Application no: H19/0424/98

Location: Pt OS 8525, Broadgate Road
Sutton St Edmunds
Spalding
Lincs

Amendment: As built - plans for farm buildings
Dwg.Nos. SM.02B; WD1890/1A & /1B

TOWN AND COUNTRY PLANNING ACT 1990
NOTICE OF ACCEPTANCE OF AMENDMENT

G. R. MERCHANT
DRAWING NO.:
SM.01 c

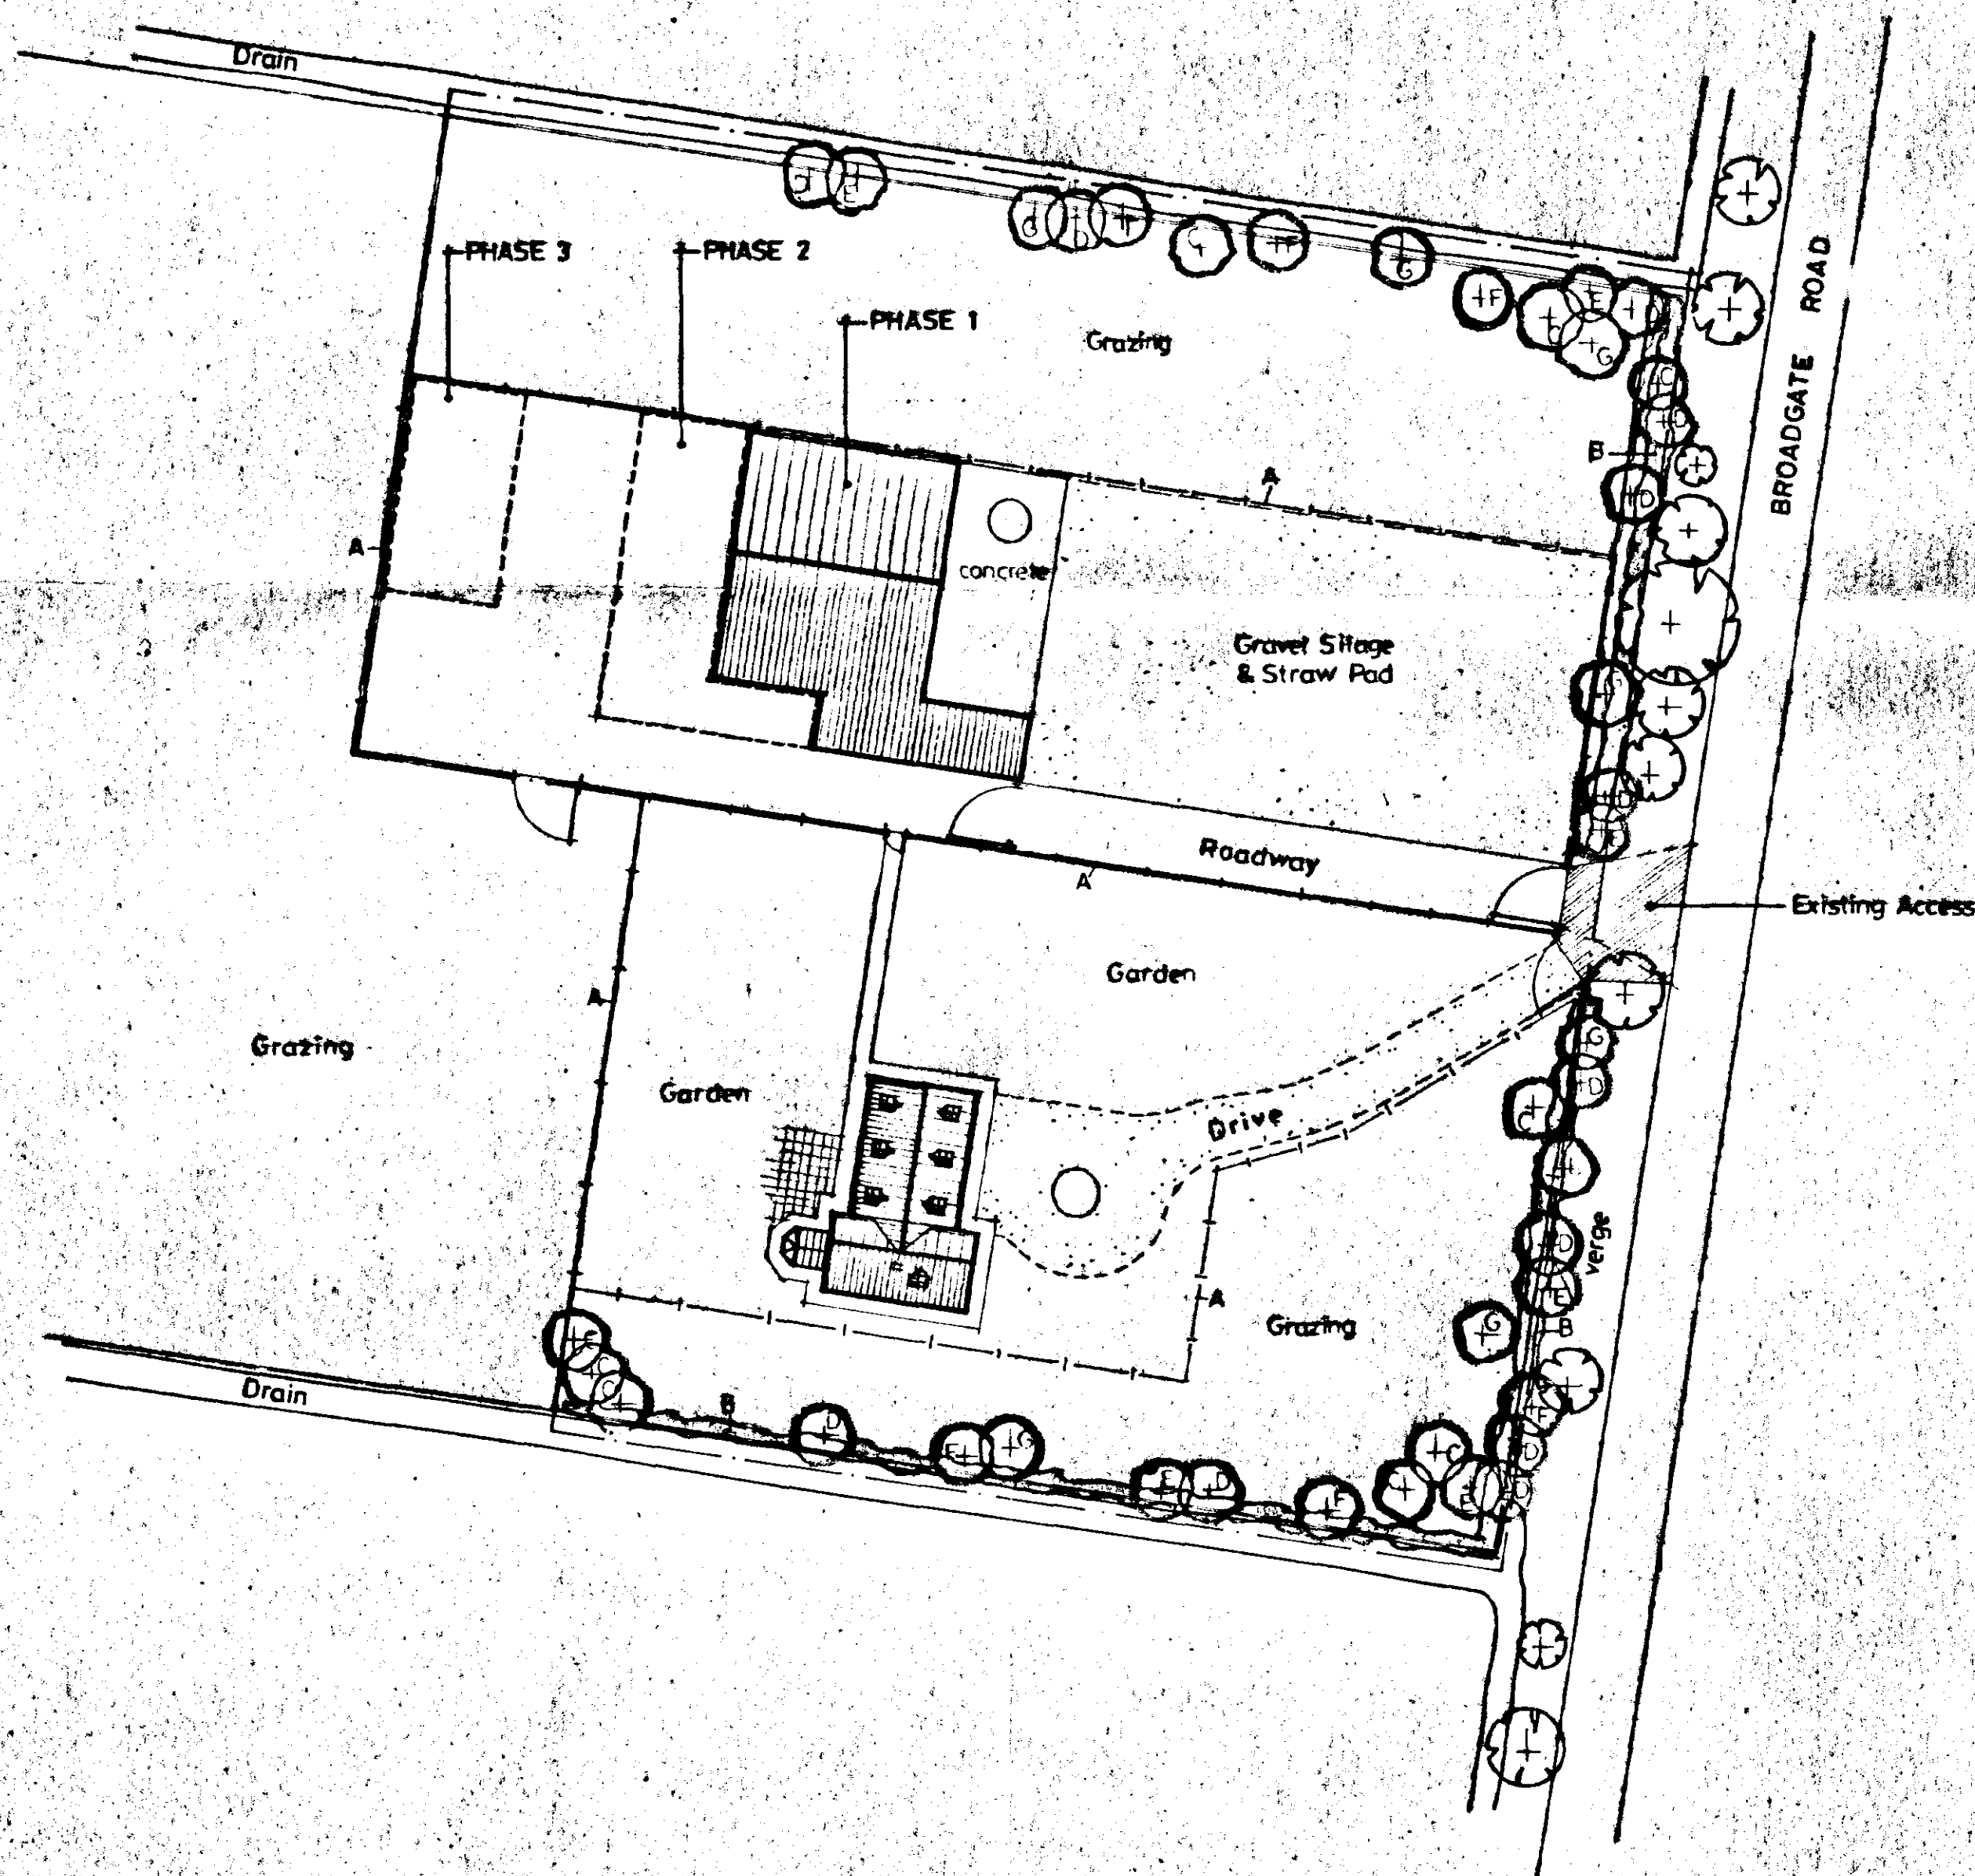
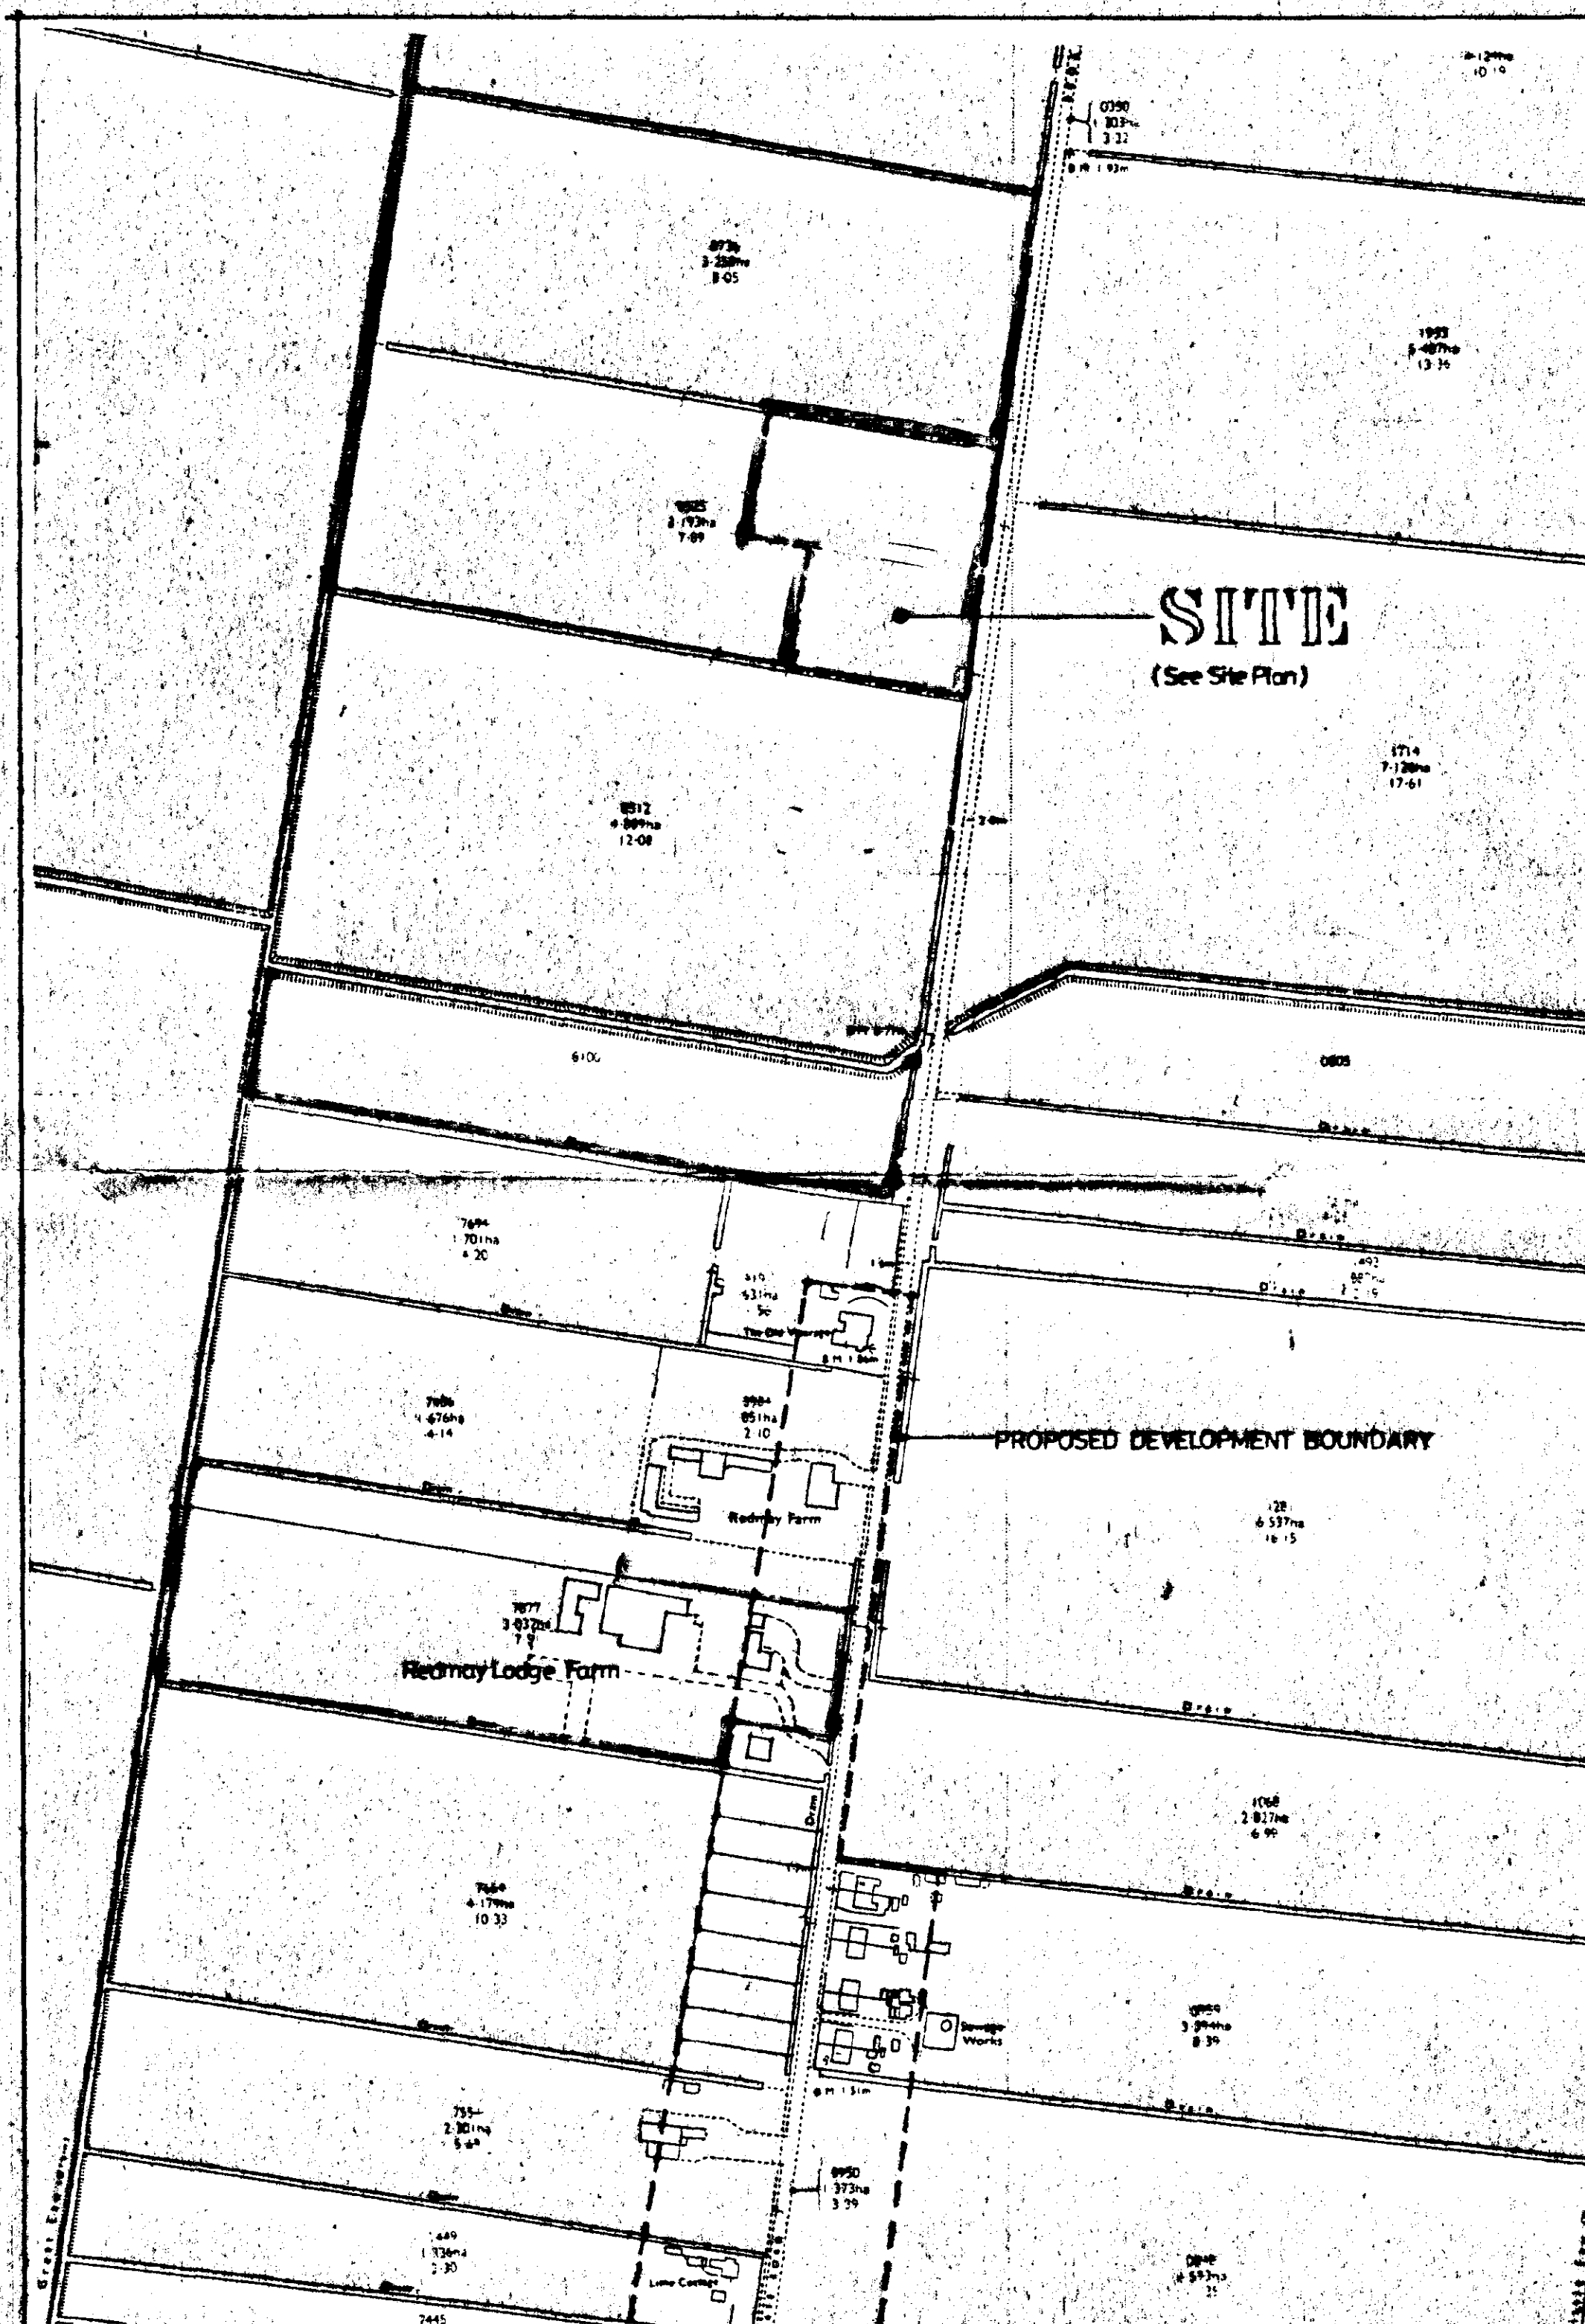
Amendment: Re-position house (6 metres to north)
Drawing No: SM.01C

RE-105/1704 HOUSE (5 METRES
TO NORTH)
